**Albuquerque Studios Master Plan
Development**

Traffic Impact Study

October 13, 2021

The following two sections in the Executive Summary list agency comments received on the draft TIS submission along with responses provided for this final TIS.

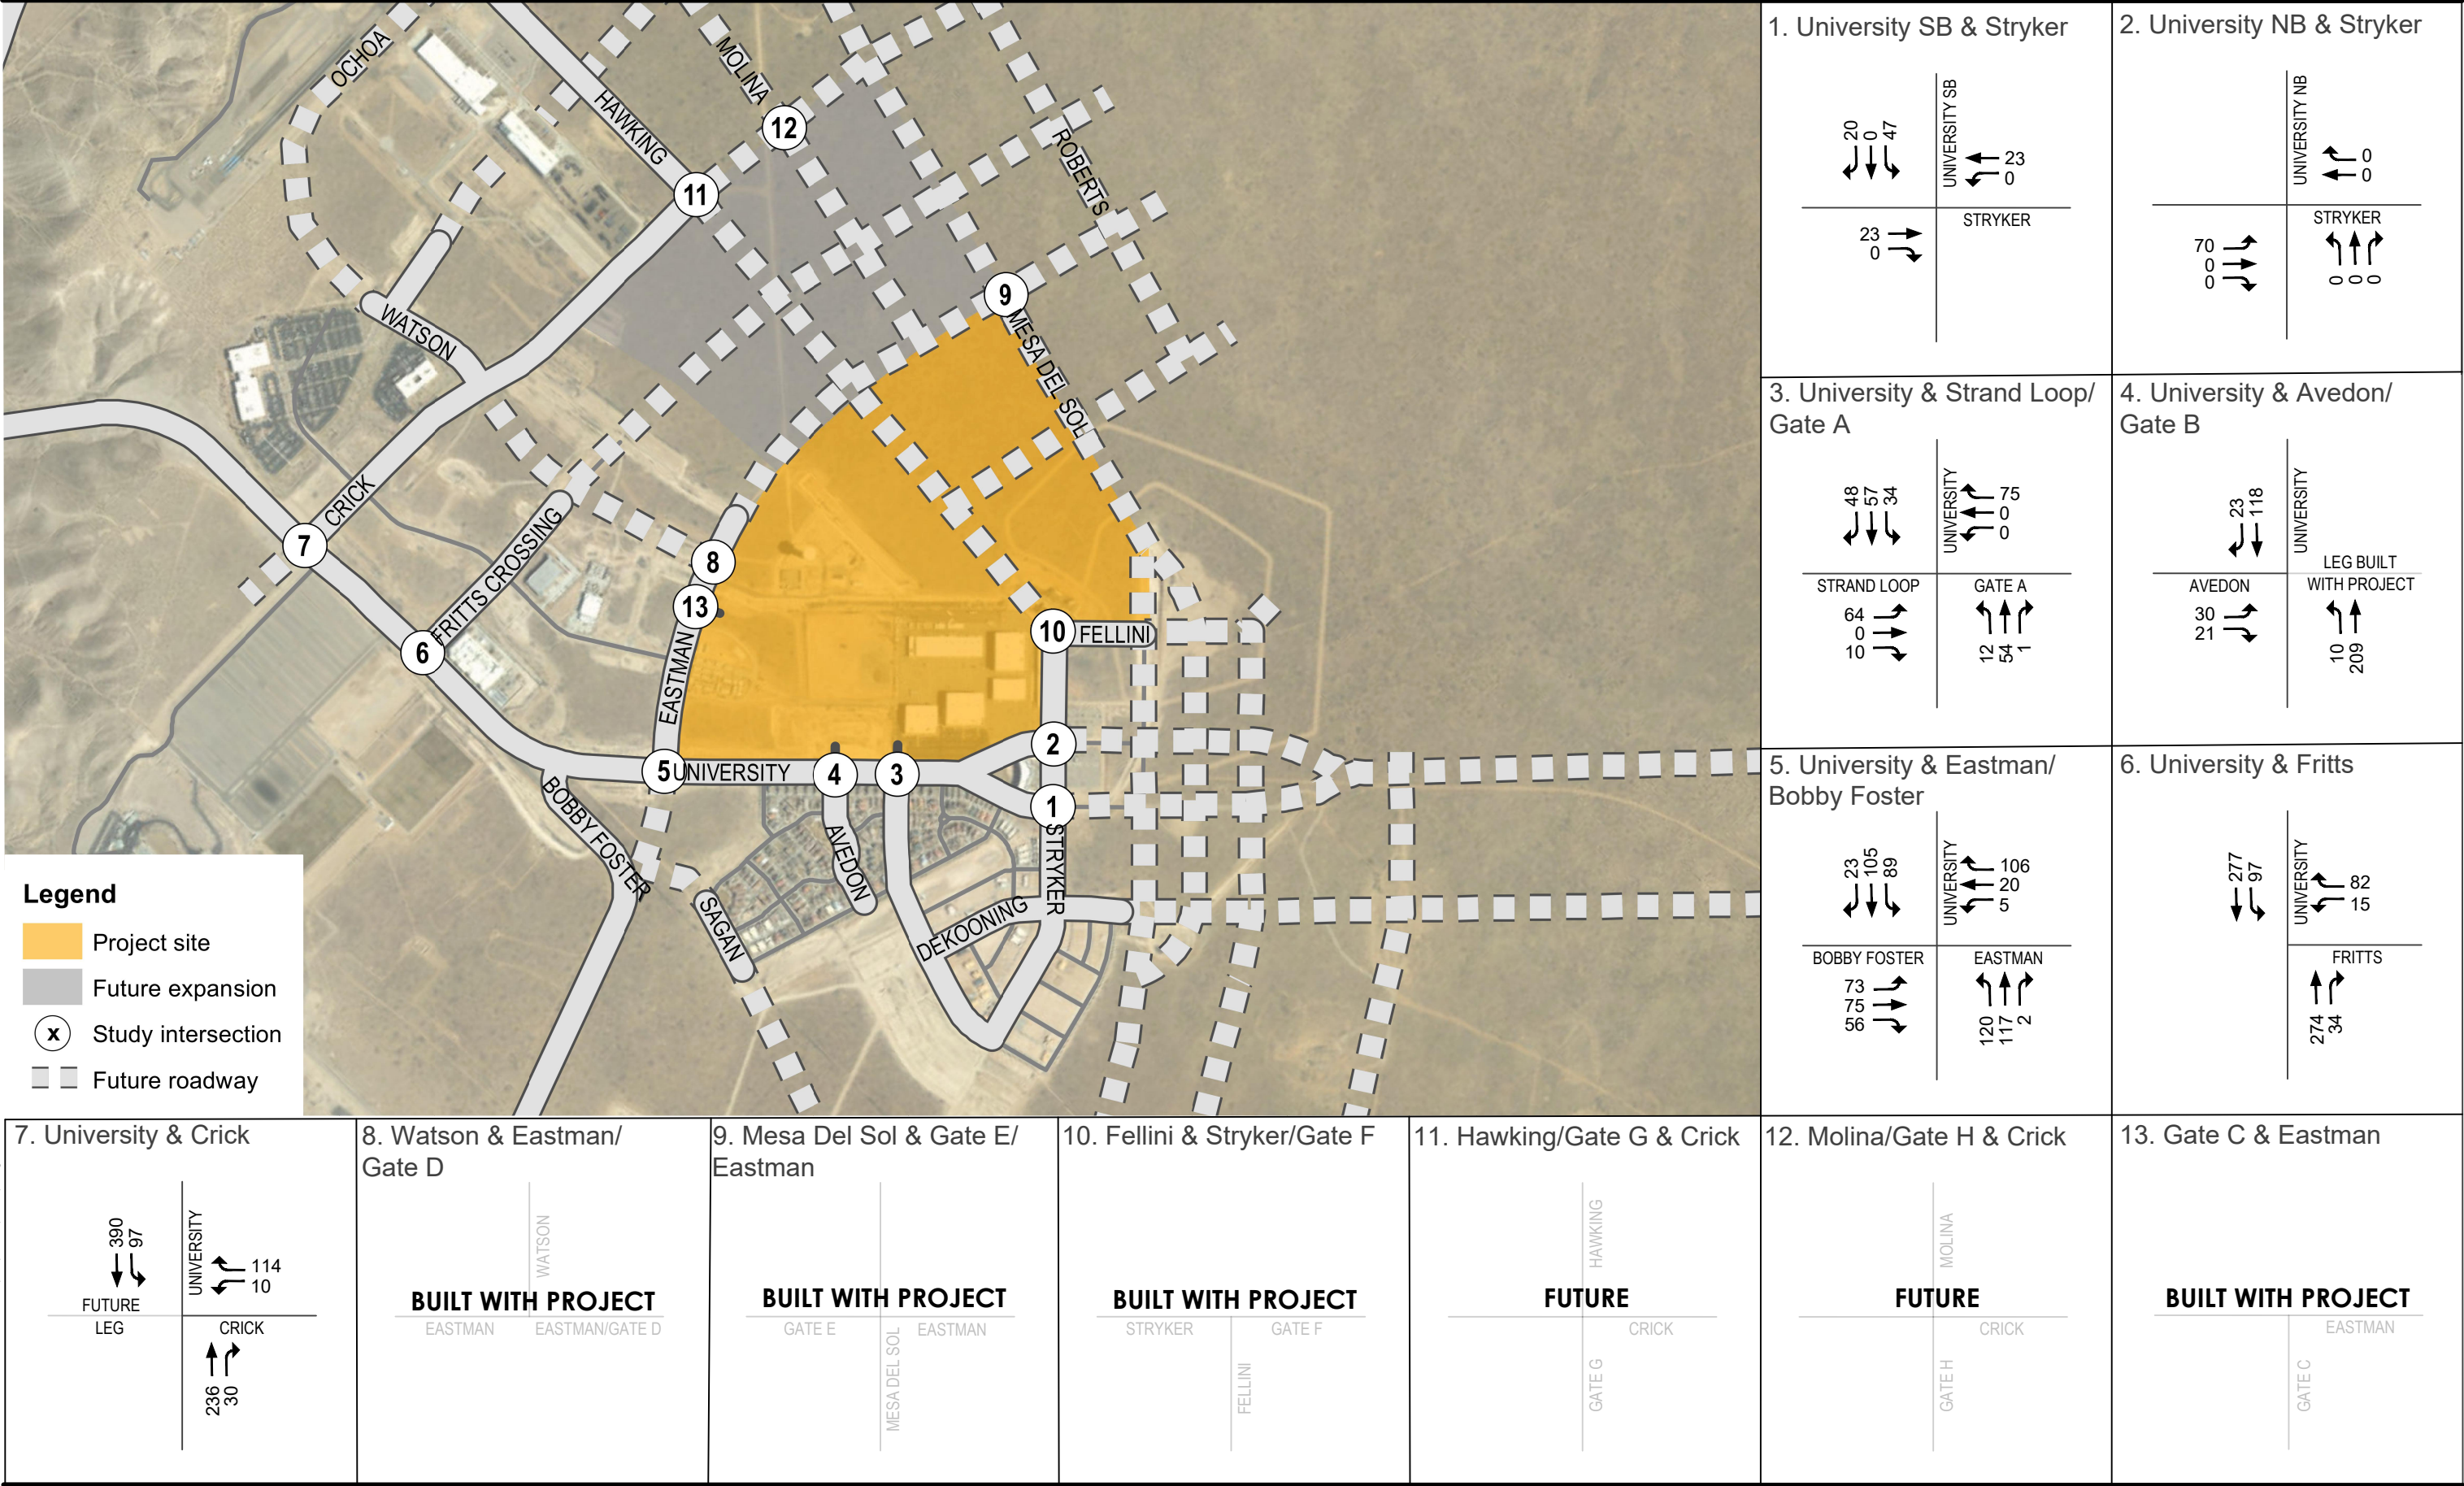
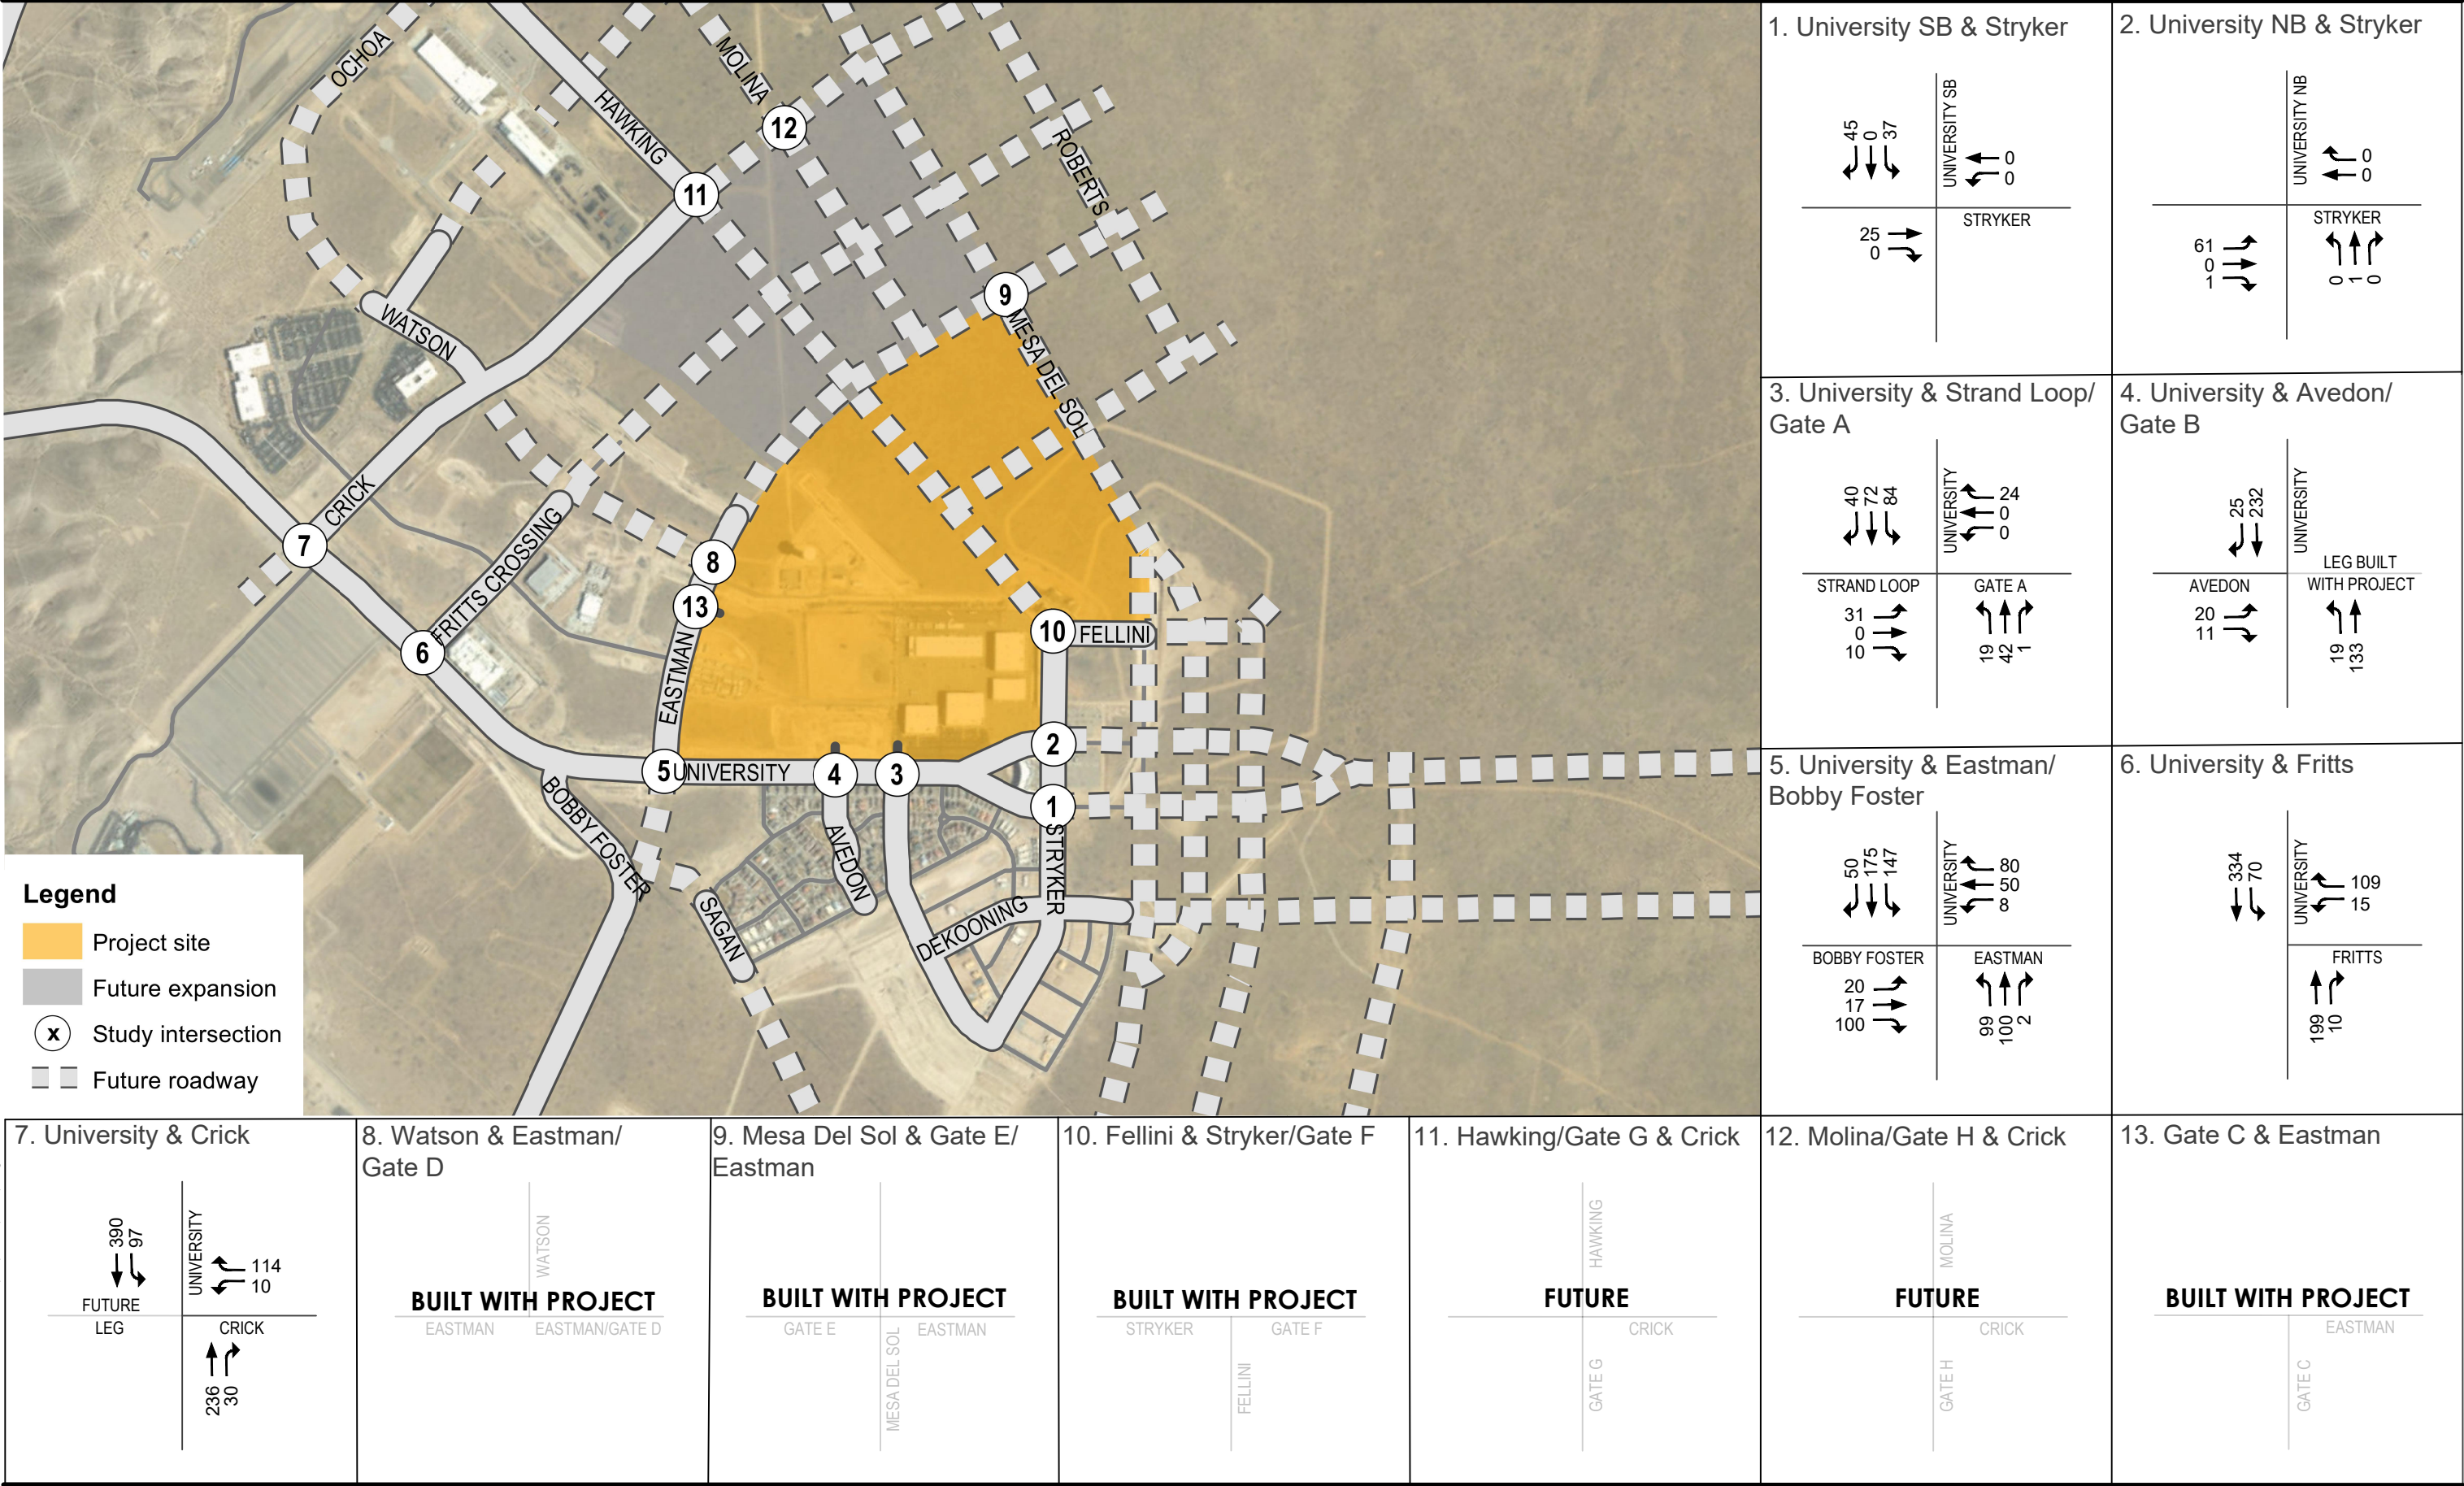
2. The trip distribution on Bobby Fosters Rd. is higher than expected. The Netflix buildout year traffic in the AM peak is 1,016 vehicles per hour (vph) eastbound and 218 vph westbound. The PM peak has 671 vph eastbound and the westbound direction has 1,523 vph. Bobby Foster does not have an interchange. The Mesa del Sol master plan committed to building the Mesa del Sol interchange. A majority of the Bobby Foster traffic should be shifted to University Blvd. As University Blvd. nears capacity the excess traffic should be shifted to Mesa del Sol Blvd.

3. Provide a justification for the amount of traffic on Bobby Foster. The level of service will need to be evaluated for Bobby Foster.

This TIS used Trip Generation estimates provided by others for Montage for contributing traffic on Bobby Foster. ½ of the Montage development traffic was

forecasted to use Bobby Foster toward University. Of that, 70% was assigned to University/Bobby Foster and 15% each to Avedon/University and Strand Loop/University.

The traffic analyses conducted on Bobby Foster included access to and from the Montage Development. A review of the preliminary site plan was used to estimate the traffic described above for Bobby Foster. An LOS analysis was conducted for Bobby Foster/University and Eastman that included the traffic forecasts. The LOS is for Bobby Foster and University is forecasted at LOS B for the Implementation Year (2026) for both AM Peak Hour and PM Peak Hour (TIS, Pg. 28). The intersection is forecasted to be LOS D (for both AM and PM Peak Hour) for the Horizon Year Analysis Period (Level B Master Plan) (TIS Pg. 29).
